# U-HAUL AT FALCON - ROLLING THUNDER WAY

## SITE DEVELOPMENT PLAN

### FALCON U-HAUL FILING NO. 1 (FALCON HIGHLANDS)

PCD File # PPR-22-56

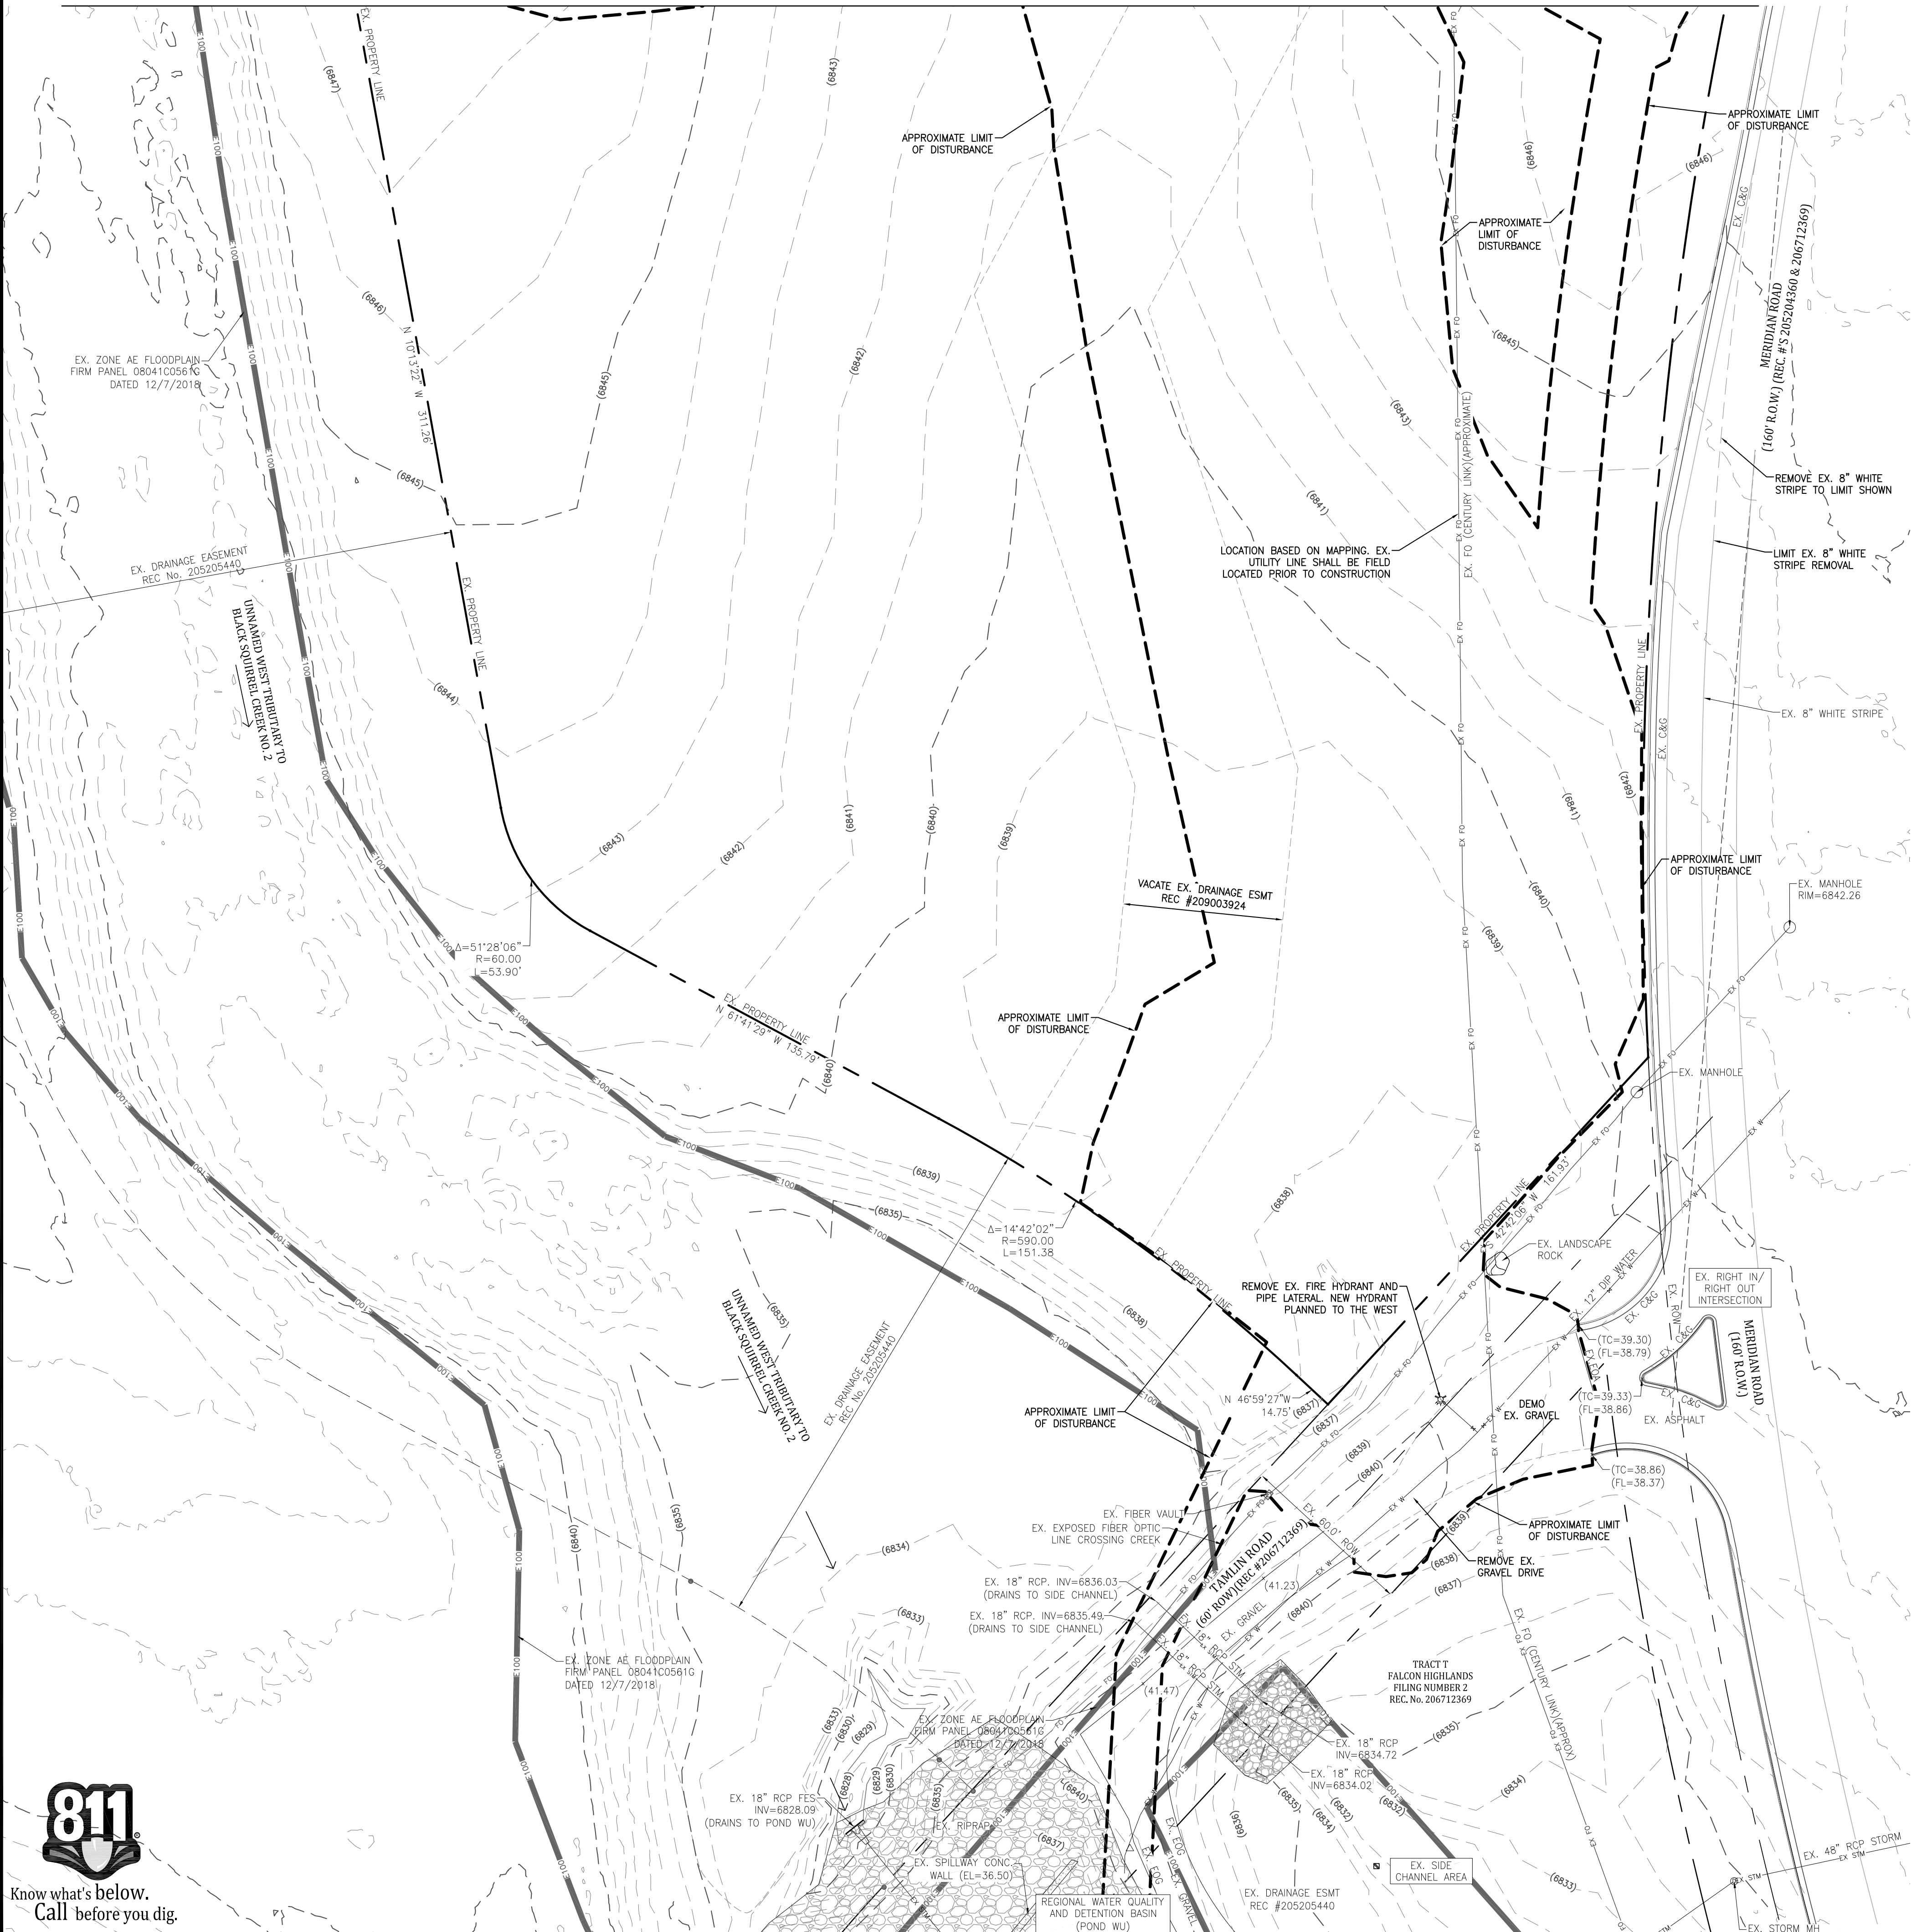
Please show existing drainage easement to be vacated with call out note

Easement and note added

DRAWN: JRD
 CHECKED: MWE
 DATE: 8/26/22
C401

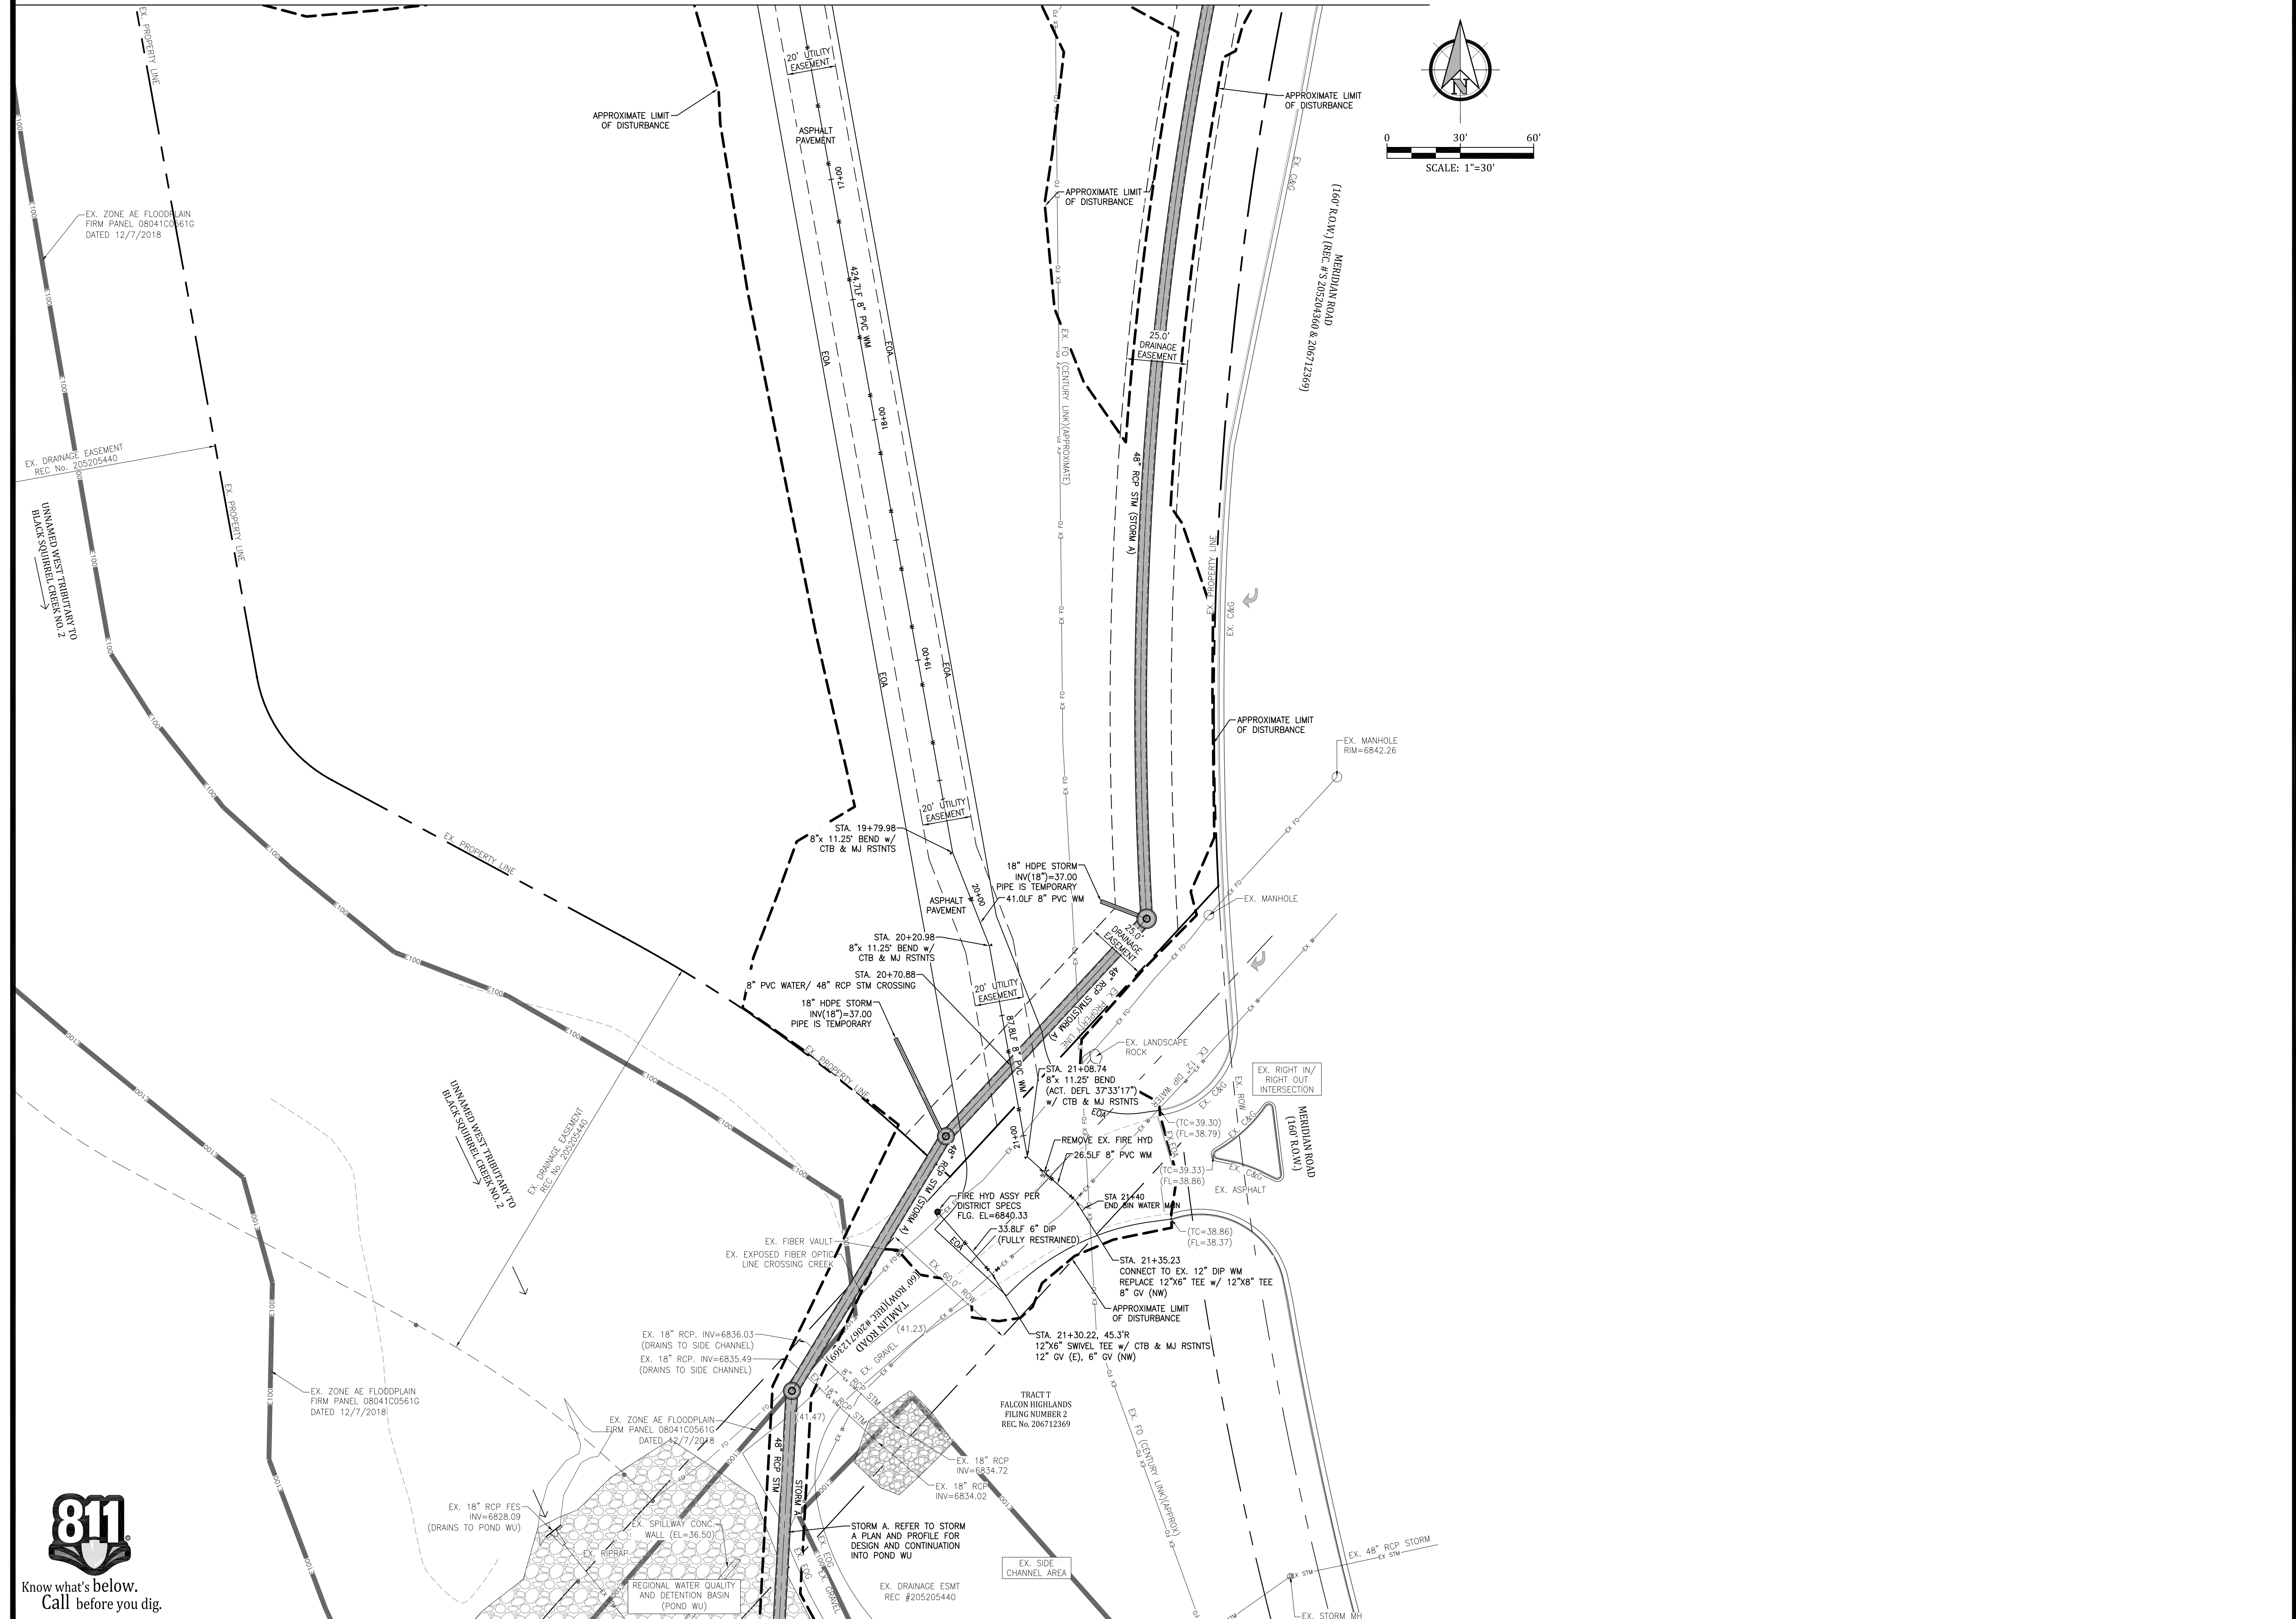
Missing  
Location of all garbage receptacles with a graphical depiction of the screening mechanism

Add Stop Sign

Note to be added with Building A
